DRainage V_1.pdf Markup Summary

FILINGS 1 AND 2
tracts AA and BB, Hannah Ridge
Subdivision Filing No. 1)
PUDSP-19-004
SF-19-006
SF-19-007
March 2019

PUDSP-19-004
SF-19-006
SF-19-007

MIDTOWN COLLECTION AT HANNAH RIDGE FILING NO. 1 DEVELOPED CONDITIONS DRAINAGE MAP			
DESIGNED BY	KRC	SCALE	DATE 03/22/19
DRAWN BY	LDB	(H) 1" = 30'	SHEET 1 OF 3
CHECKED BY		(V) 1" = NA	JOB NO. 1116.30

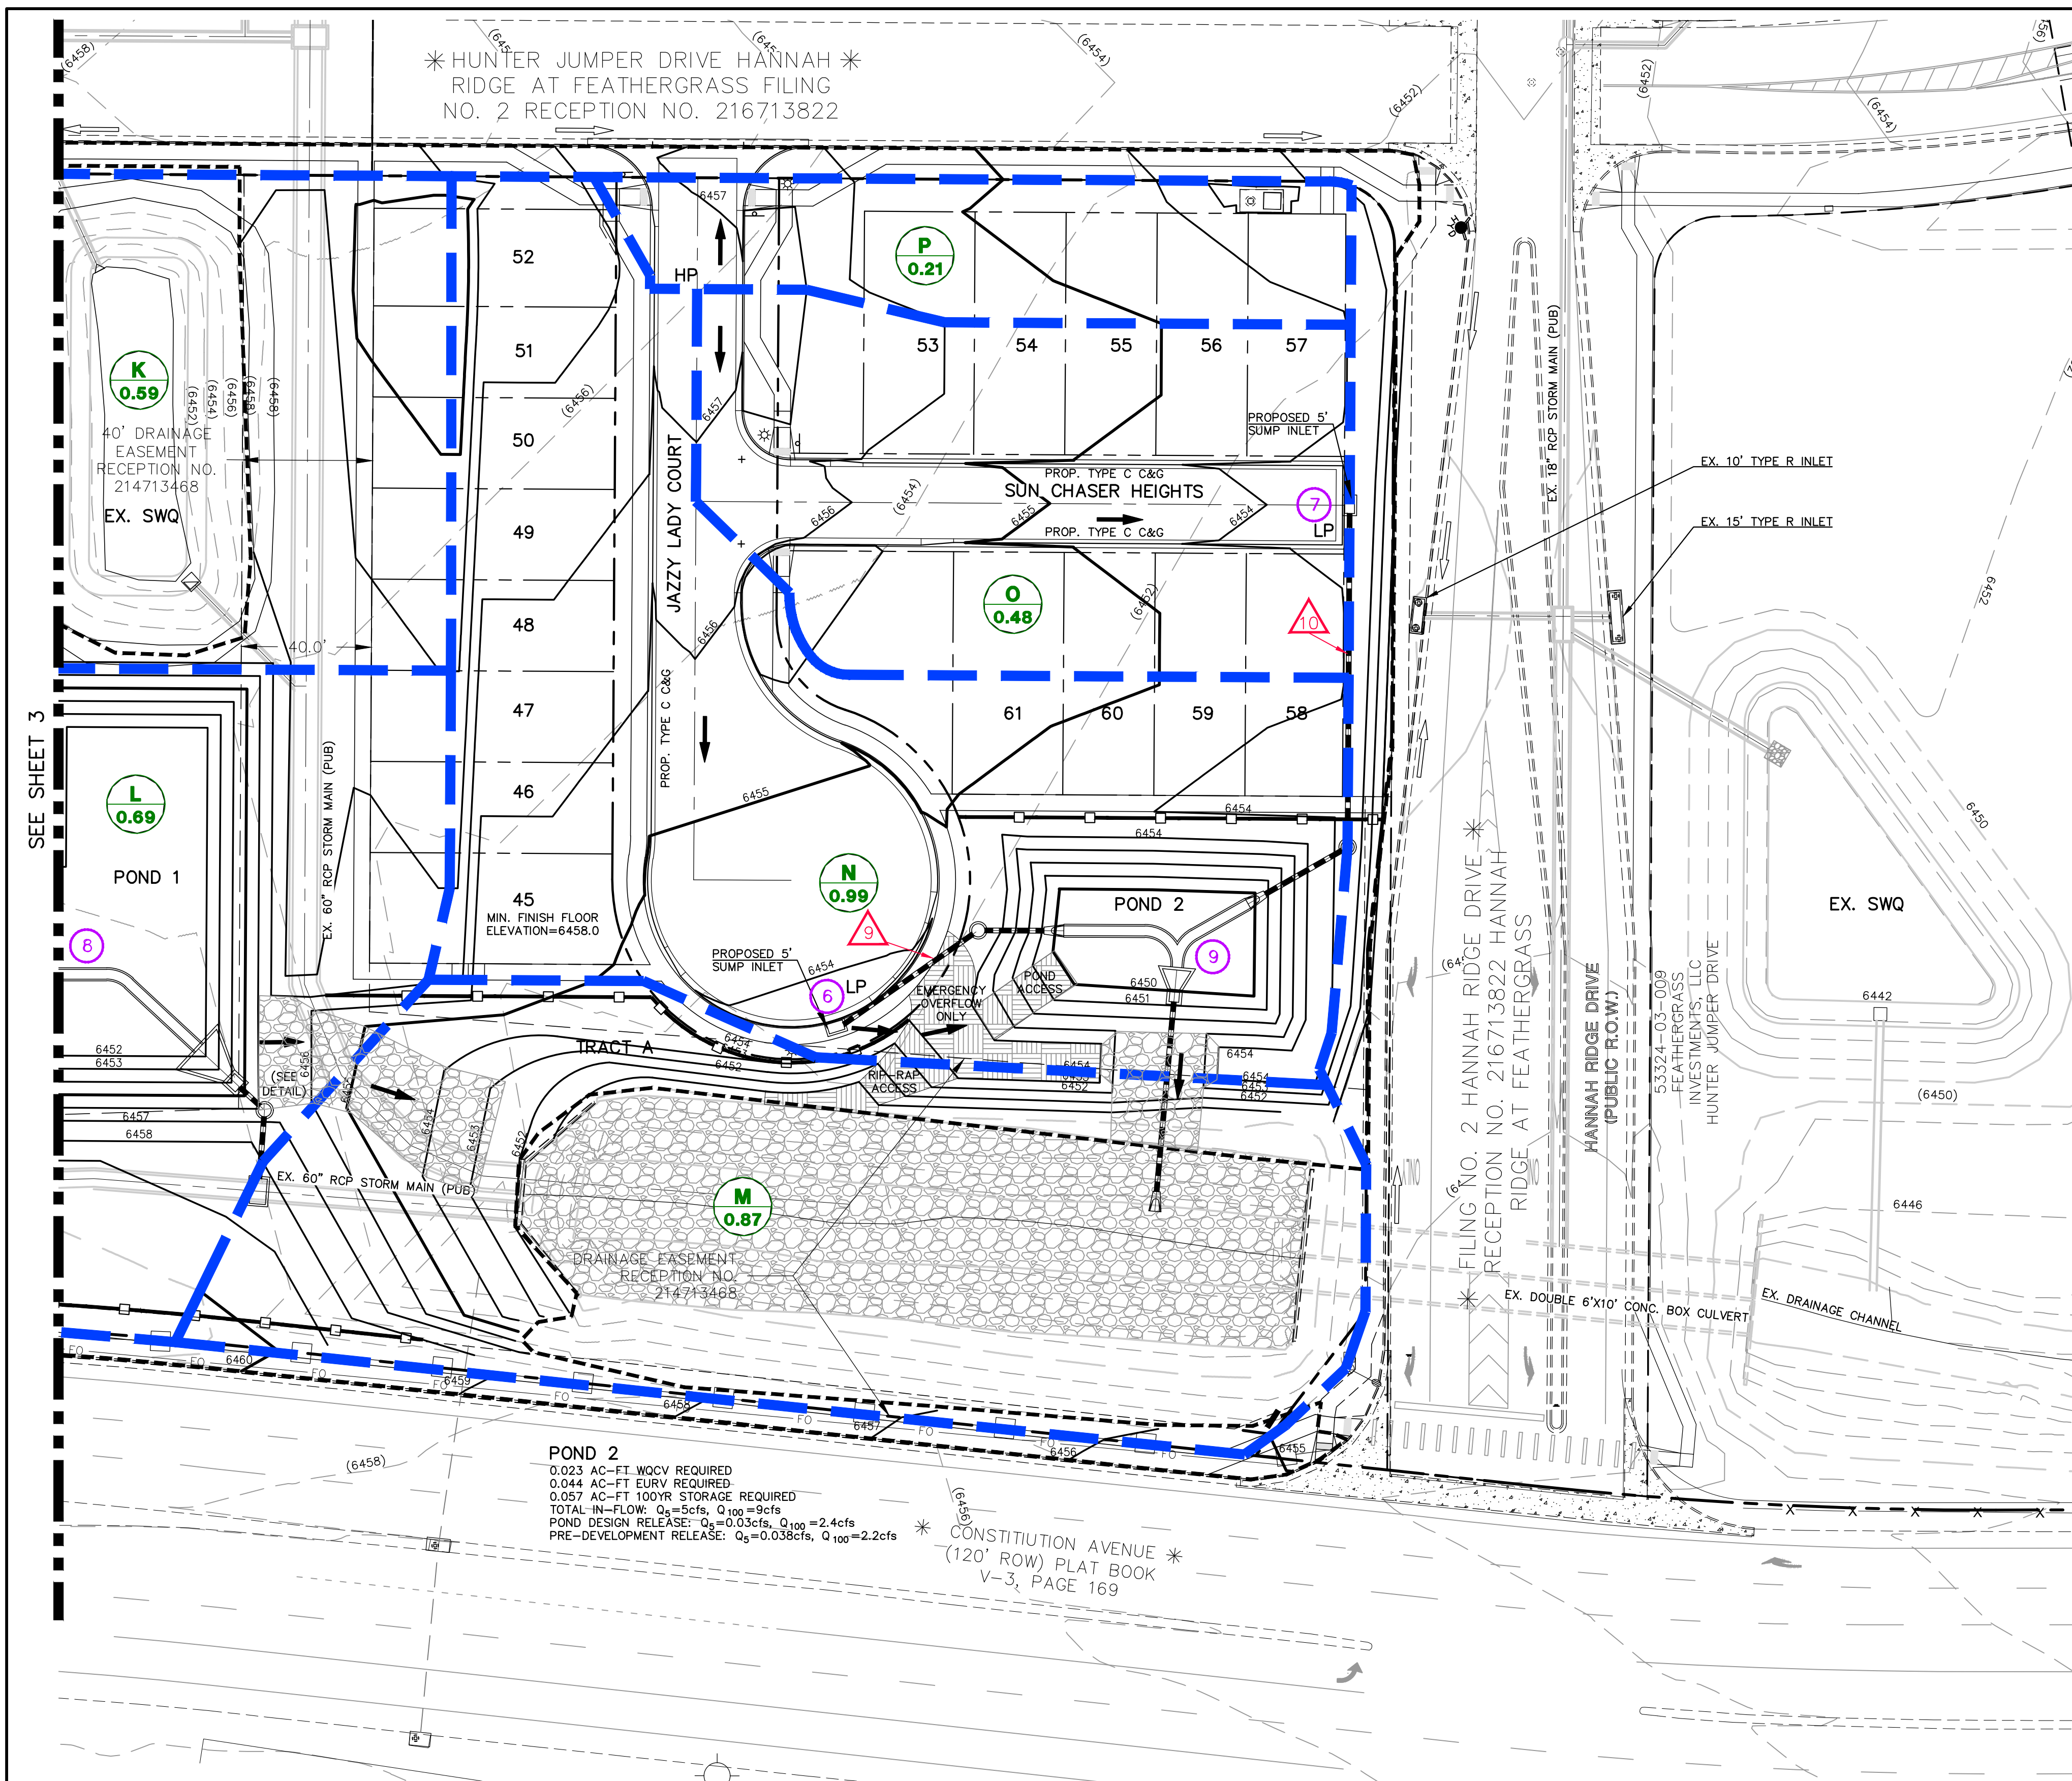
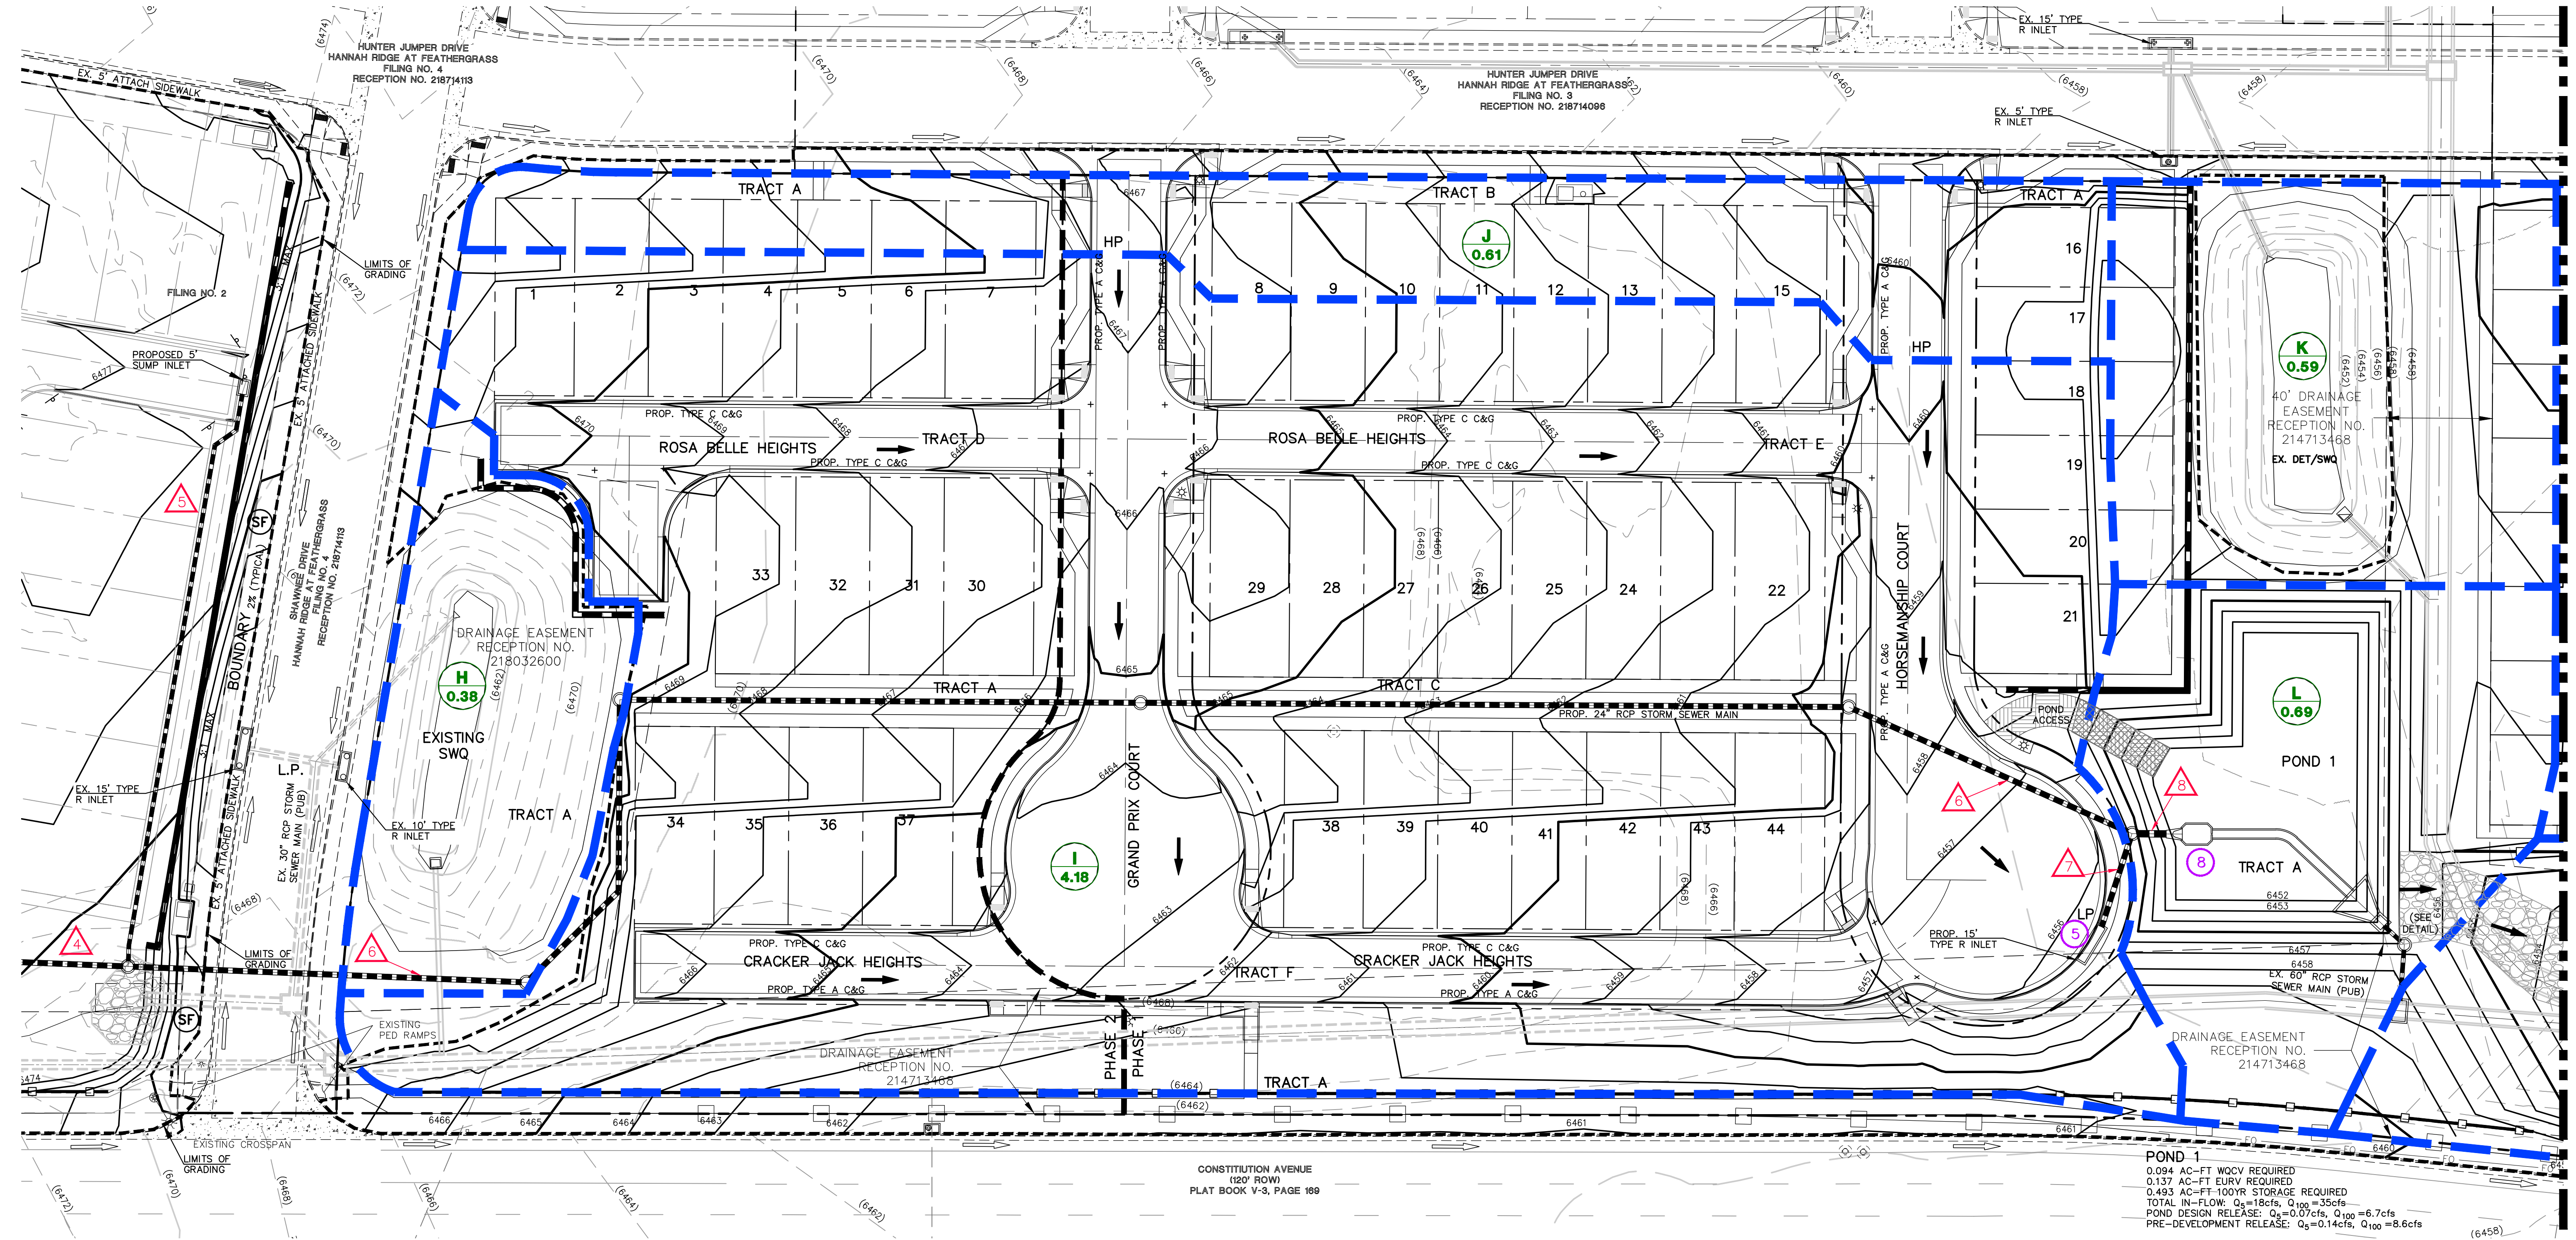
Call out design point 9.

Call out design point 8.

Basin E needs to flow to a Detention SWQ facility.

Provide a summary of all design points for all design flows. In a table, on these plans. Sheet 33?
Darken design points so they can be identified on a printed version.
Basin E needs to flow to a detention/SWQ Facility.
